From: Martyn White
Sent: 19 October 2018 09:32
To: Planning.Responses
Subject: BR/236/18/L

BR/236/18/L

PROPOSED 'CONSERVATION TYPE' ROOF WINDOW, AND
110mm Ø PIPE FOR STORM WATER

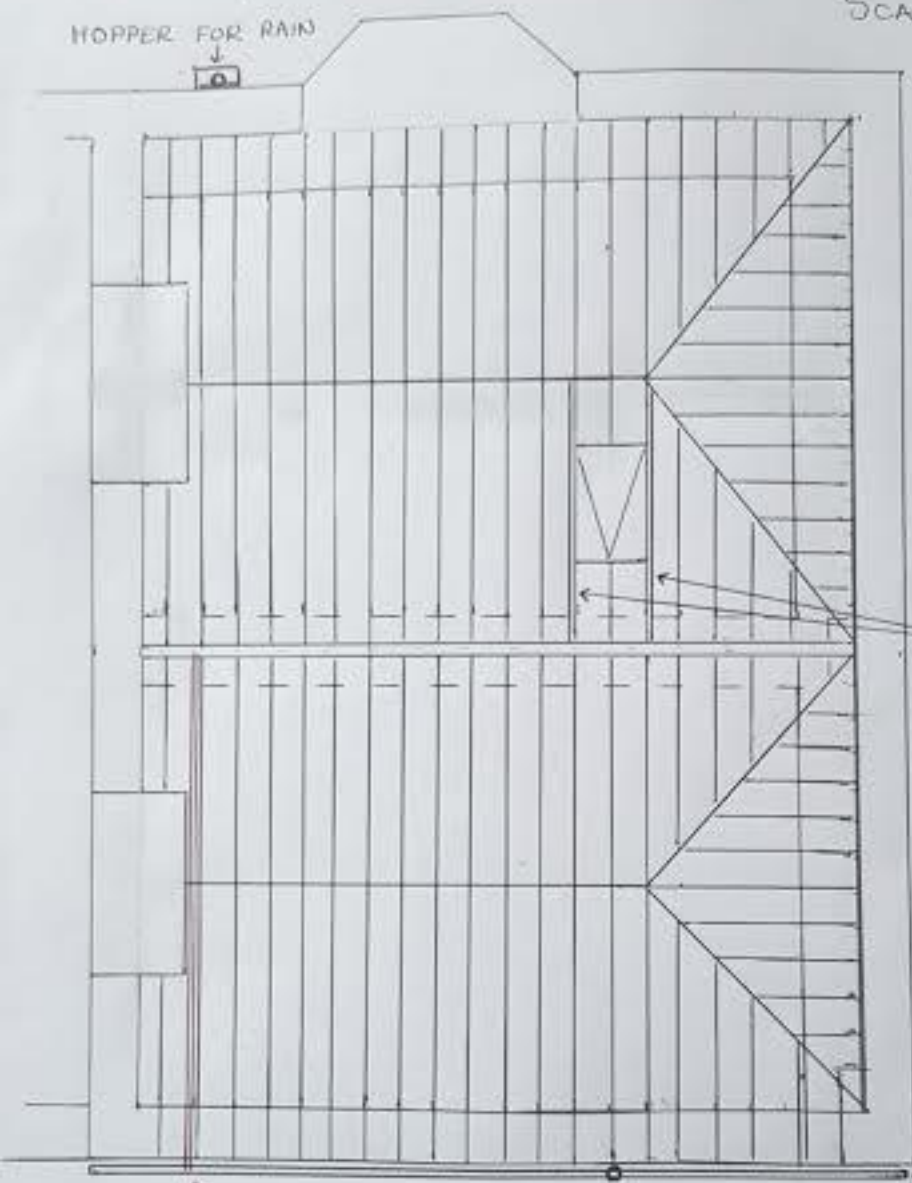
The proposed insertion of a roof light allows access to the roof for on-going maintenance, but should be of a conservation standard. Such an approach is acceptable. In addition, relocation of the living room door is also acceptable in this instance.
